REF: 101 Brookmans Avenue, Brookmans Park, AL97QG

Title: Non Material Minor amendments application house 5
houses : 6/2020/0592/VAR

This application is for the alteration to approved drawing 485018- 21 under application 6/2020/0592/VAR

Org.No. 485018-21 Rev. A

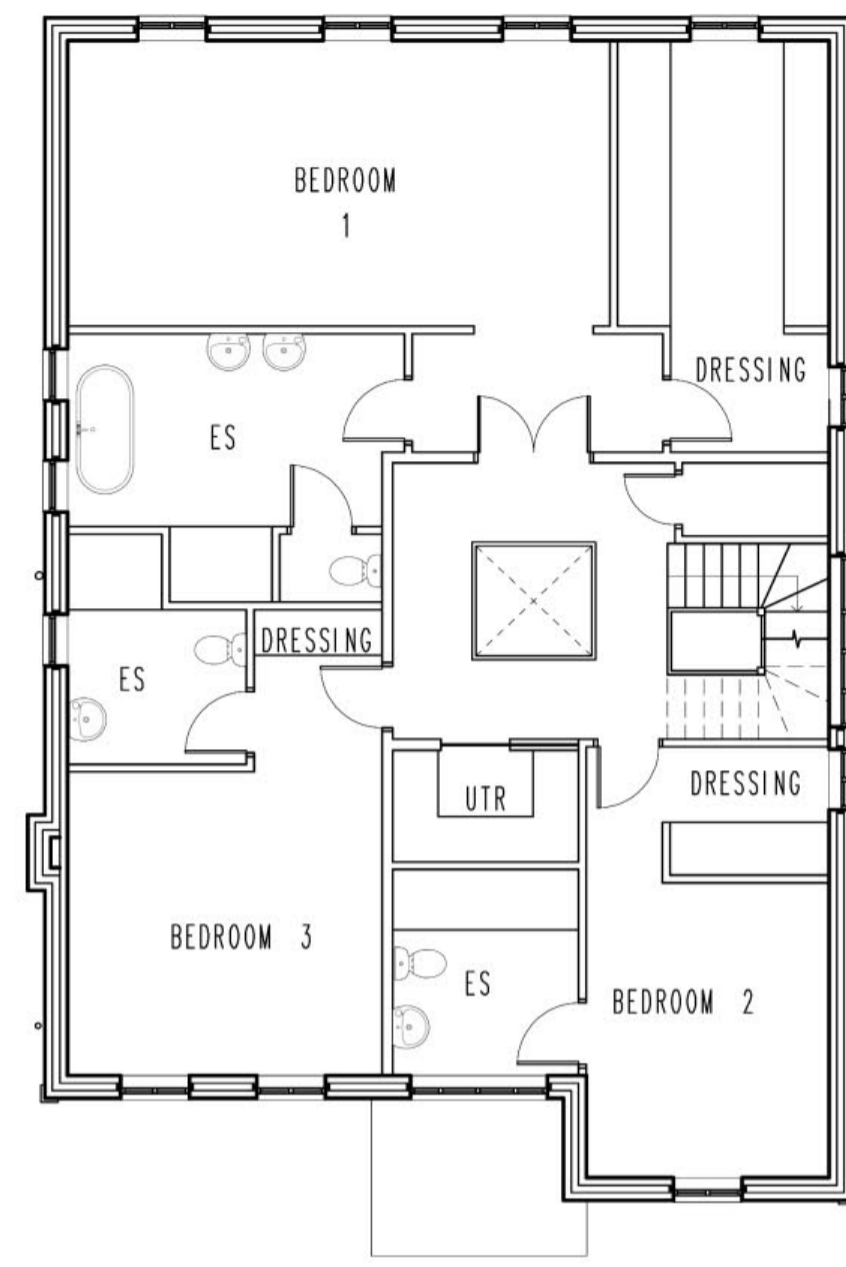
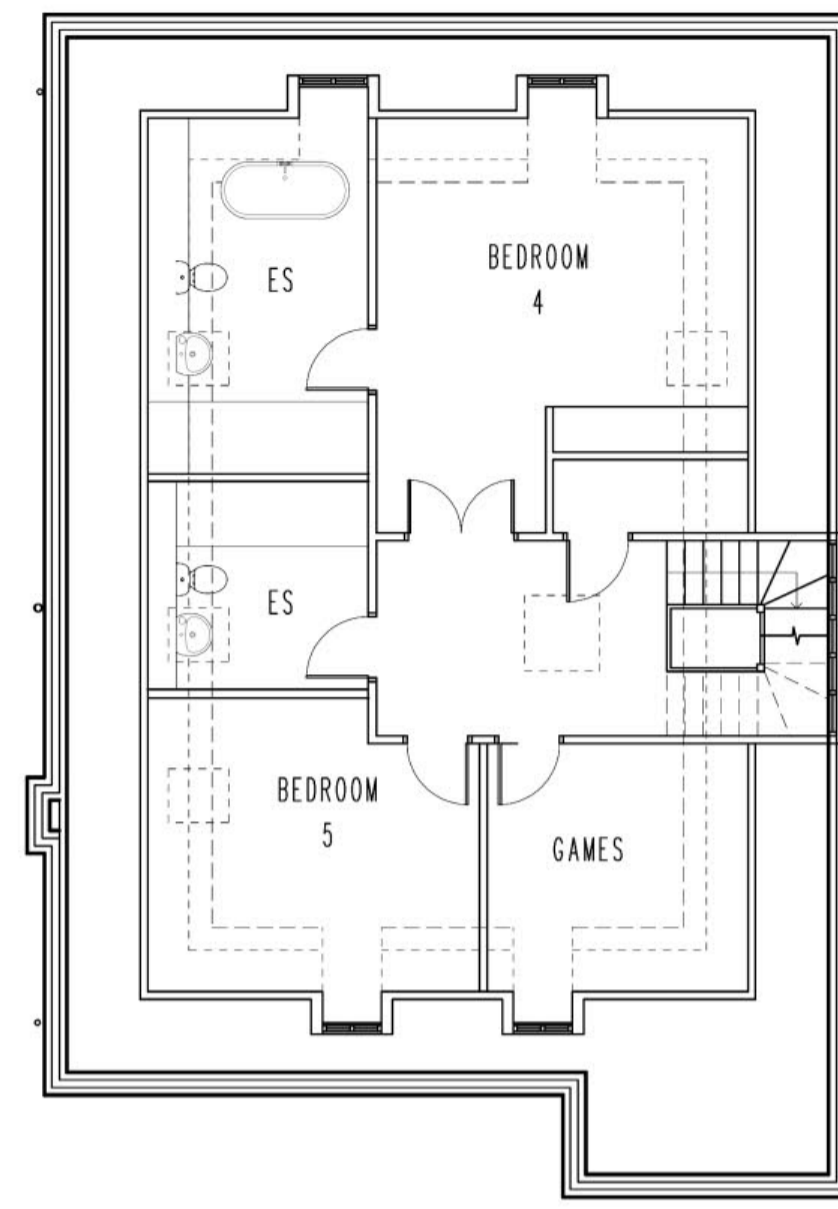
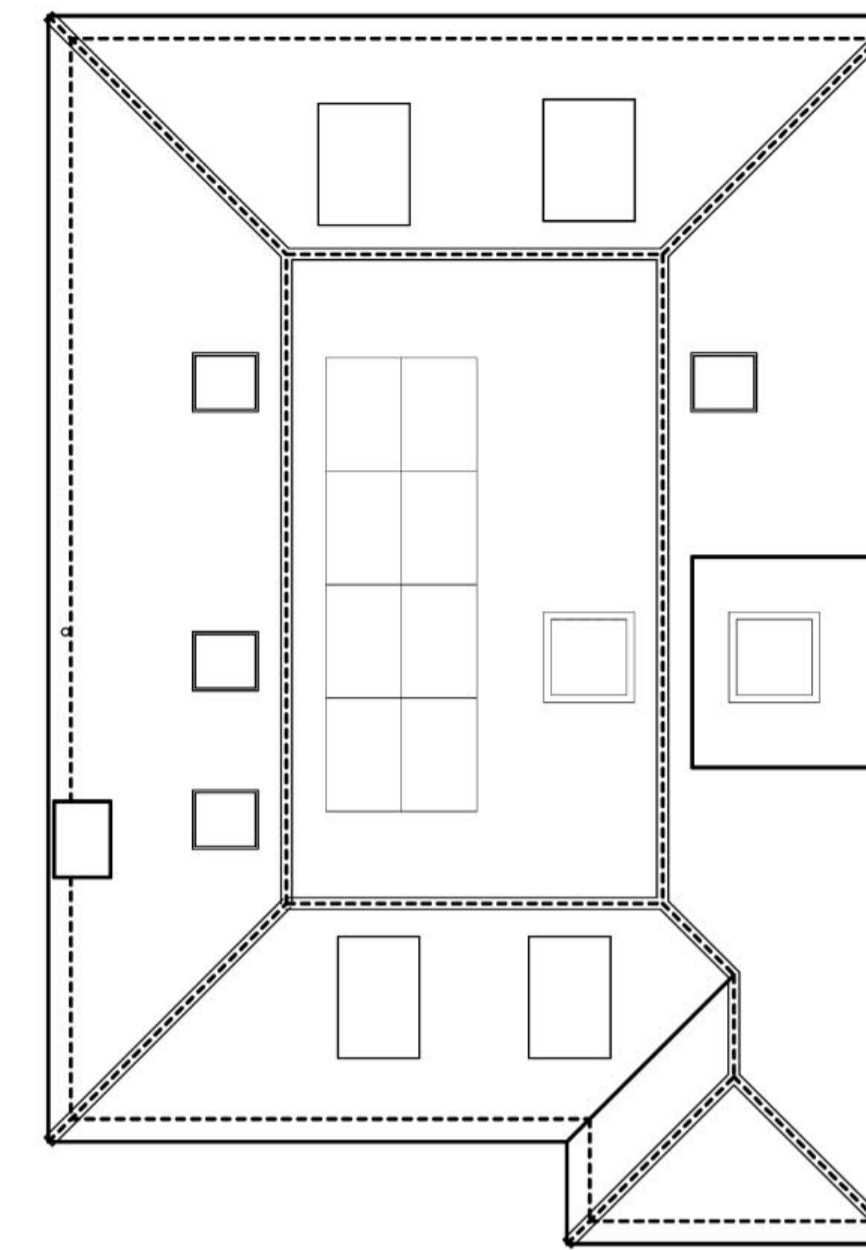
The treatment of brickwork has changed from the approved drawings
